DRB Comments

PROJECT # 1002786

APPLICATION # 04-01635

RE: Gateway Park/SPBP

CHAMISA or Spanish Broom
5 Gallon
(Moderate Water Use)

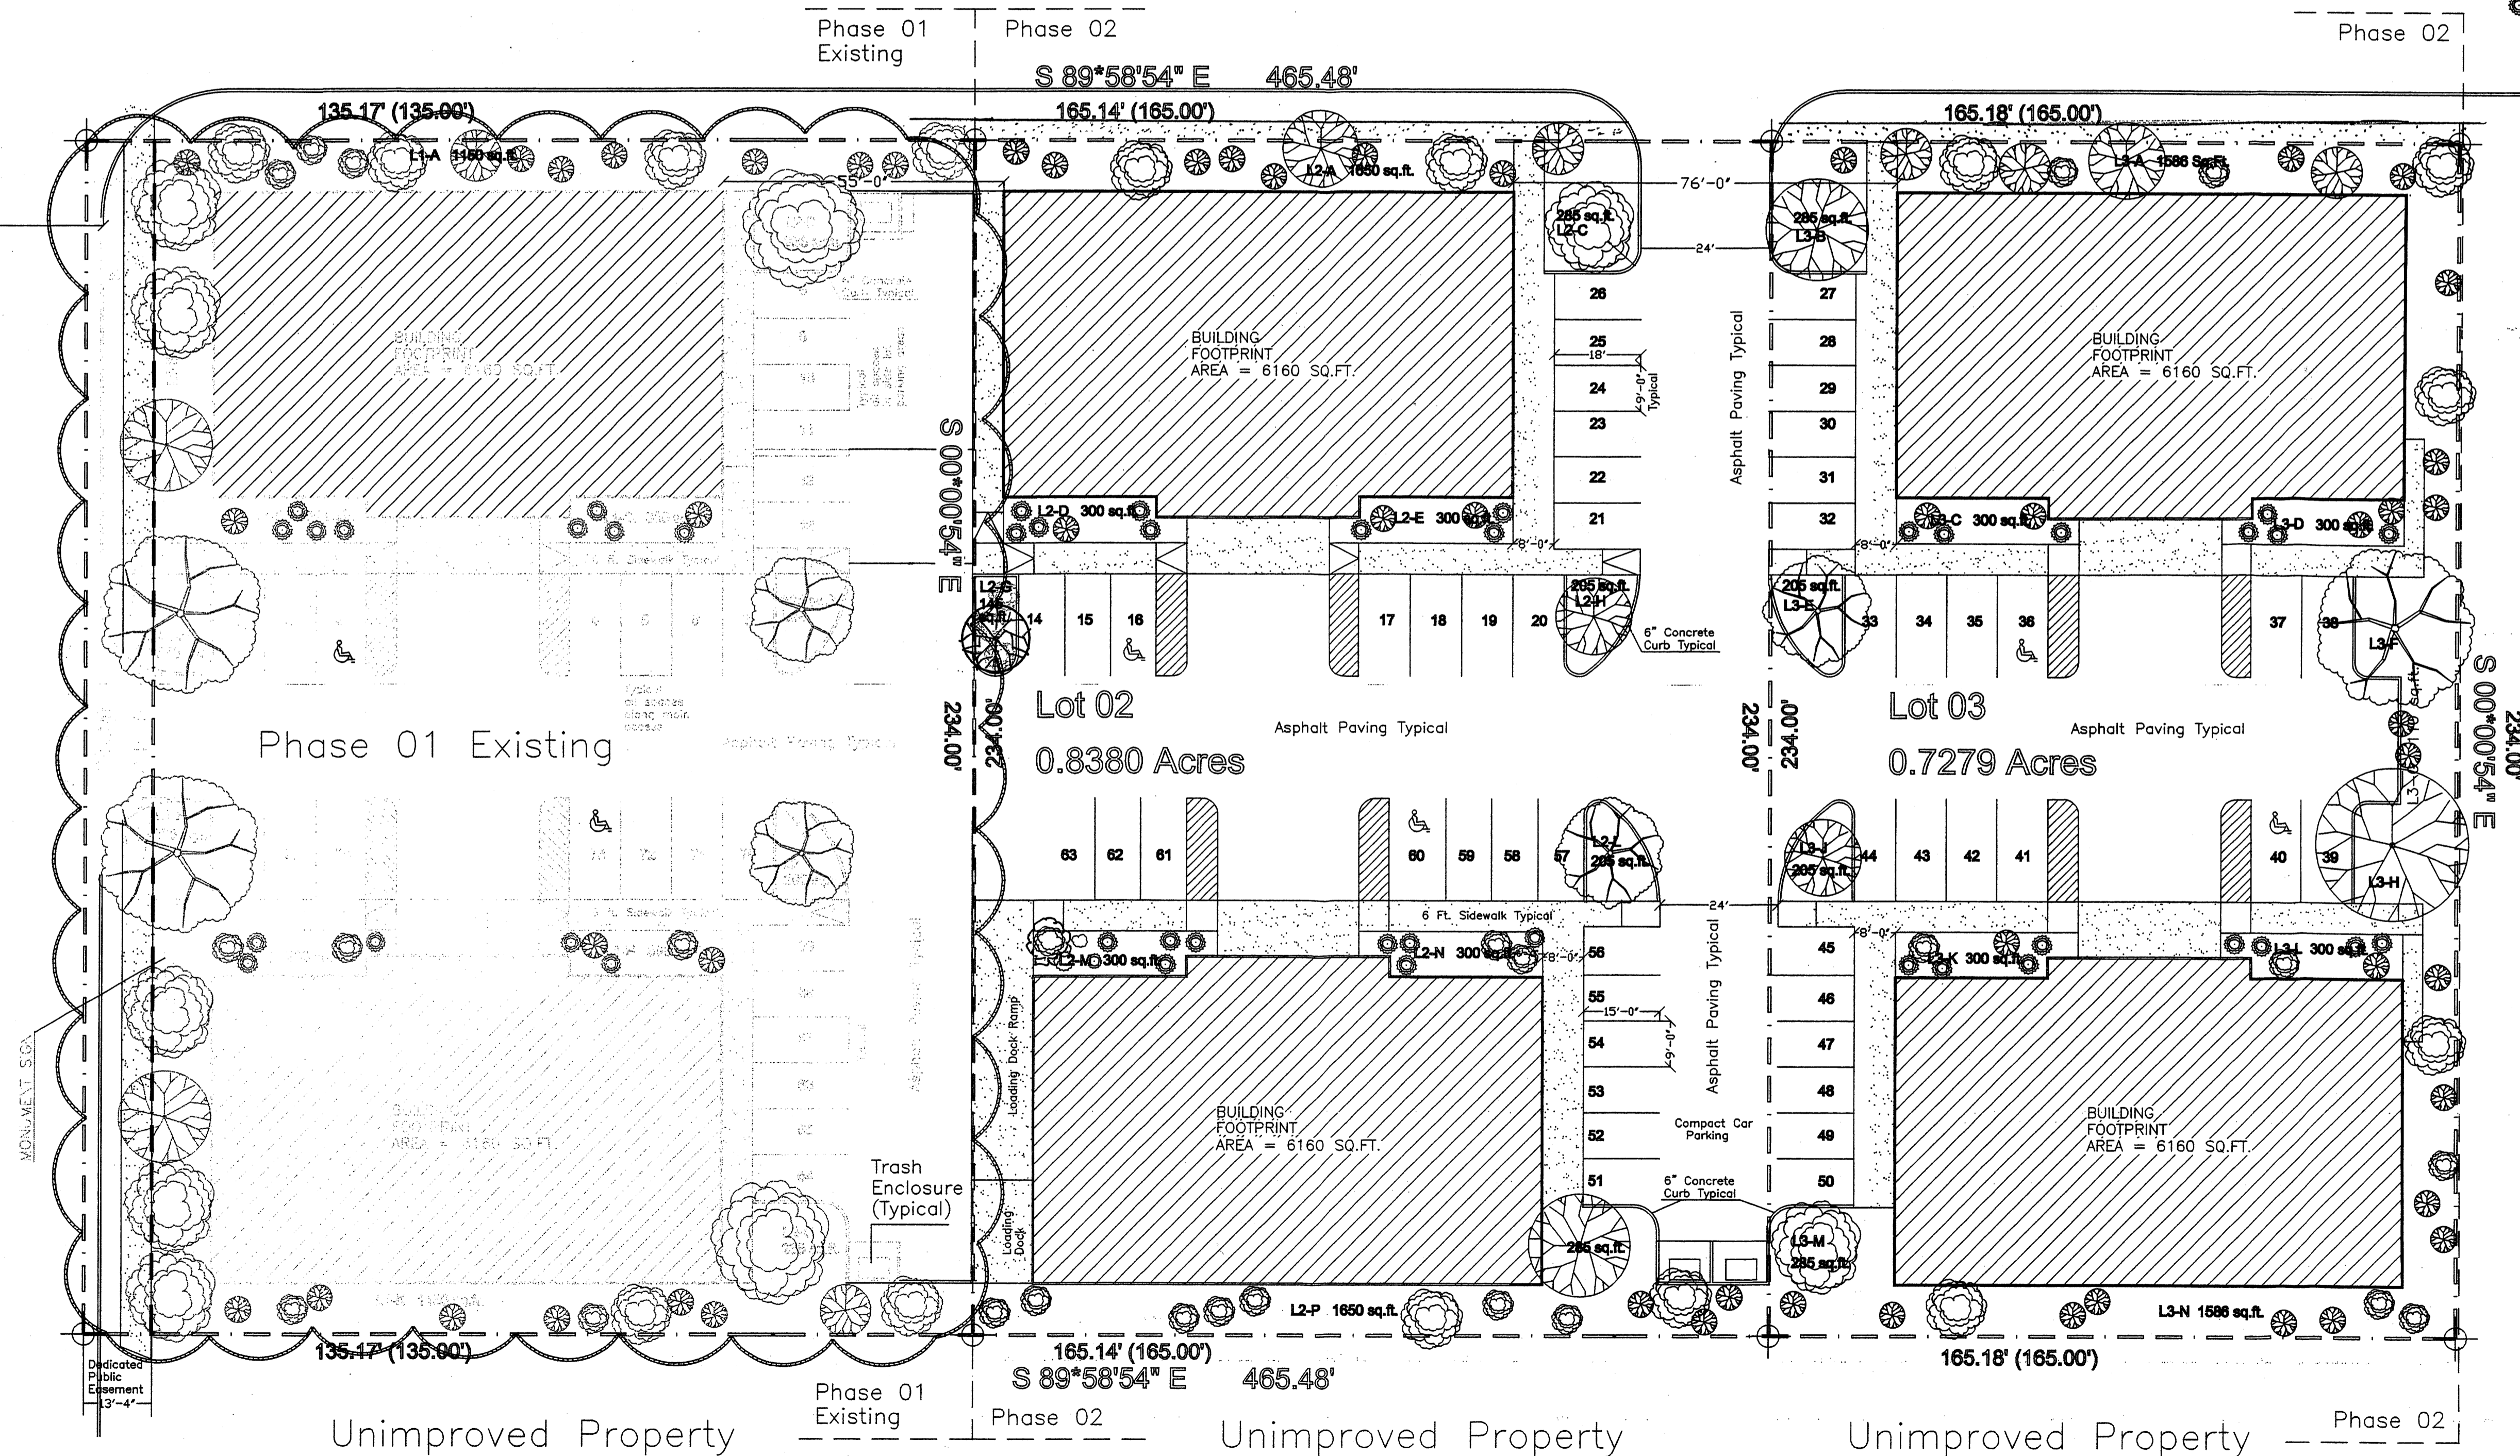
- ✓ 5. Are any walls or fences planned? *None*
- ✓ 6. The details on site lighting should be on the site plan. *None*
7. Landscape Plan.
 - Spanish Broom should not be planted right next to sidewalks. They spread out over the sidewalk

- ✓ ▪ The water usage of the plants (H, M, L) must be on this sheet.
 - The 10' landscaped setback required along Beverly Hills & San Mateo must include a combination of trees, shrubs and vegetative ground cover. See the North I25 SDP, page 54. Please make the necessary additions & corrections.

- ✓ ■ Some of the parking spaces on the sides of the buildings are more than 50 feet from a tree. The North I25 SDP, page 55, requires 50 feet or less.
